Recommendation Report for Planning Permission for Works or Extension to a Dwelling

REF NO: BN/36/21/HH

LOCATION: 20 Elm Grove
Barnham
PO22 0HJ

PROPOSAL: First floor extension over existing garage and porch to front

FOR MR & MRS THURLOW		
SITE 20 ELM GROVE, BARNHAM, WEST SUSSEX. PO22 0HJ		
TITLE PROPOSED FLOOR PLANS		
SCALE 1:100	DRAWN AH 11/20	DRAWING NO. 04 REV A

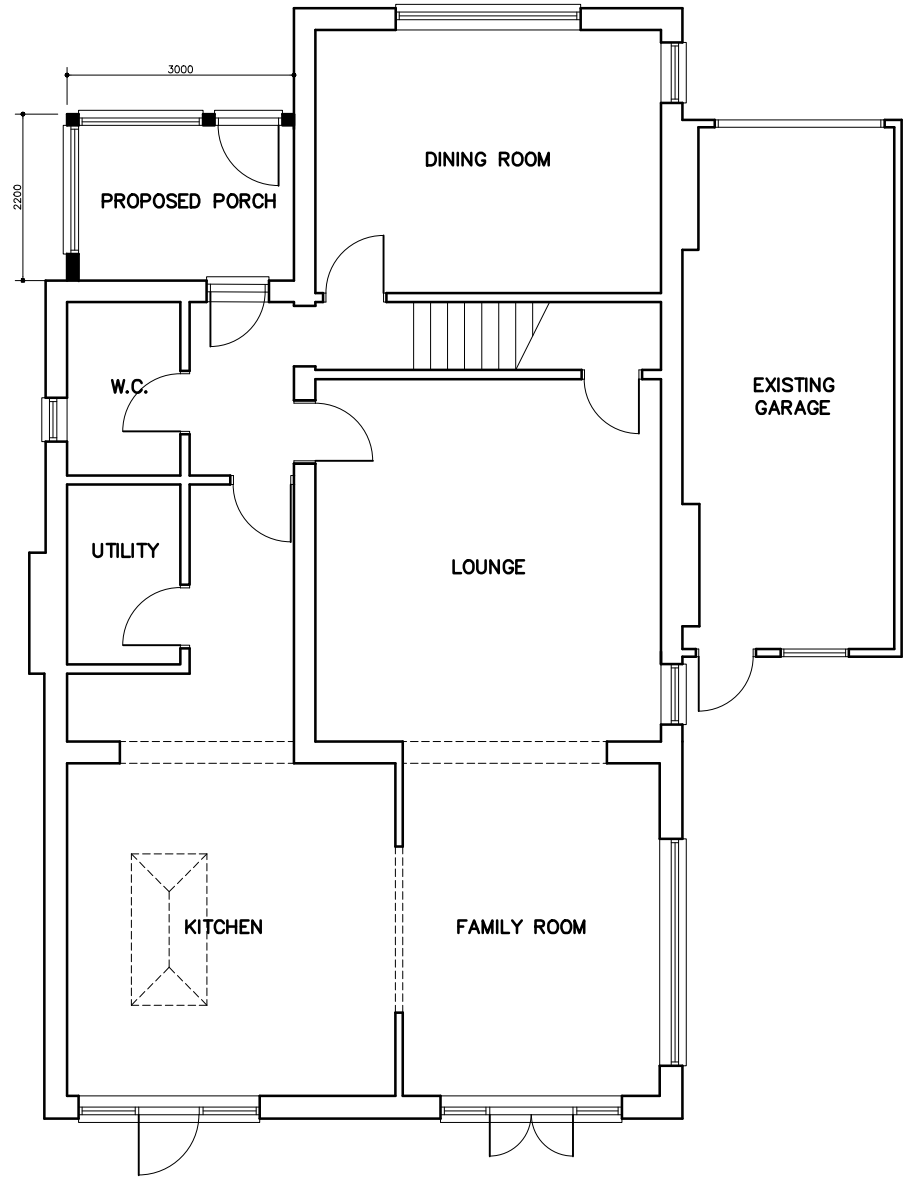
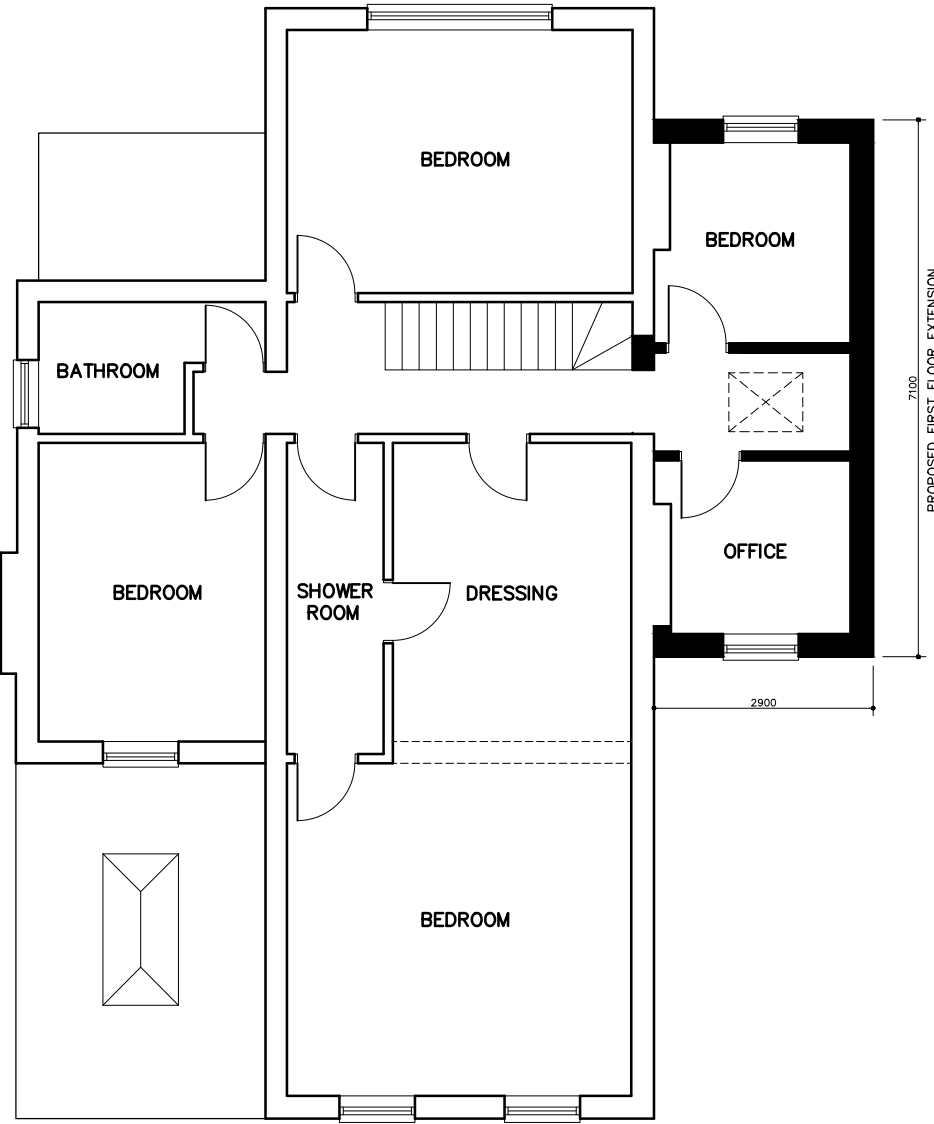
The porch only projects 2.2m from the dwellinghouse.

It would not cause a loss of light to, an overbearing impact upon or a loss of privacy to neighbouring dwellings. The proposed front porch does not breach a 45 degree line drawn from the nearest window of

the neighbouring dwellinghouse and would therefore comply with the 45 degree rule which the Council uses to assess loss of light to and overbearing impact upon neighbours windows.

FOR	MR & MRS THURLOW		
SITE	20 ELM GROVE, BARNHAM, WEST SUSSEX. PO22 0HJ		
TITLE	PROPOSED ELEVATIONS		
SCALE	DRAWN	DRAWING NO.	
1:100	AH 11/20	05 REV A

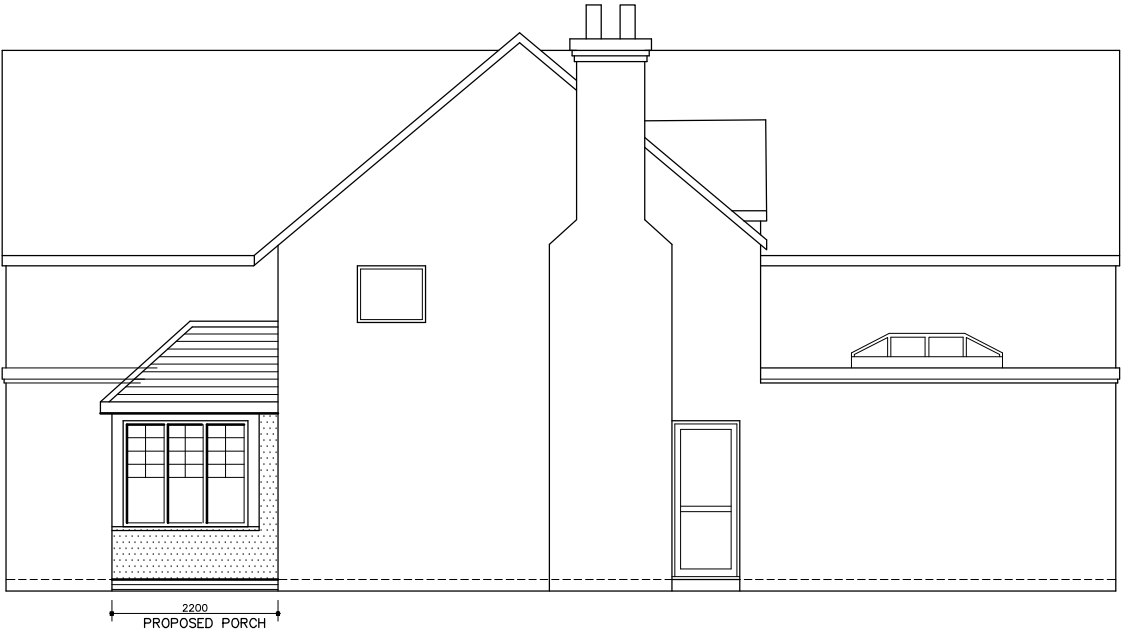
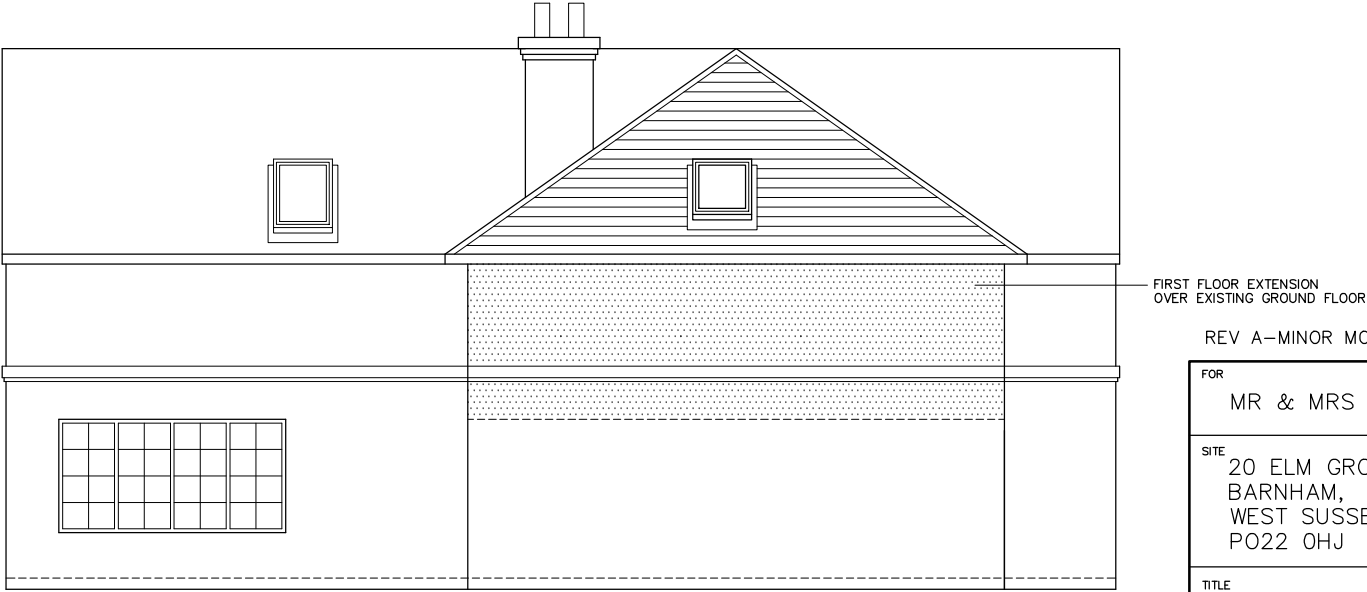
There is an attached flat roof garage which extends along the south eastern side of the dwelling. This will be increased in height and will have a pitched roof to form habitable accommodation at first floor level. The first floor extension does add bulk to the property, however the neighbouring dwellings have a variety of extensions and therefore it is considered to appear in appropriate in relation to the character of the area and does not appear as an alien feature. There is a significant amount of glazing in the garage addition which would be unusual in the street scene but by reason of its design does not cause demonstrable harm to the character of the area.

The porch by virtue of size and location is does not adversely impact the spatial pattern of the street scene as such is deemed to accord with policy D DM1 of the Arun District Local Plan. The proposed development will be carried out using materials which match in appearance the original dwellinghouse. The development due to the siting and design accords with D DM1 and D DM4 of the Arun Local Plan.

There will be an extension to the south eastern side of the dwelling at first floor which will extend the ridge of the dwelling by around 2m, located to the top of the garage. This runs along the side of the boundary with 2m and as such is not deemed to result in adverse overbearing due to the existing built form on the boundary.

Whilst the proposal conflicts with D DM1 (d) of the Arun local plan as it removes the 1m separation distance at first floor it is not to the detriment of the application. Furthermore, the overbearing impact is reduced through the lack of windows on the side elevation of the neighbouring property.

There will be additional rooflight to the south eastern elevation and windows to the first floor of the garage which will view rise to views over the street scene and rear garden of the dwellinghouse.
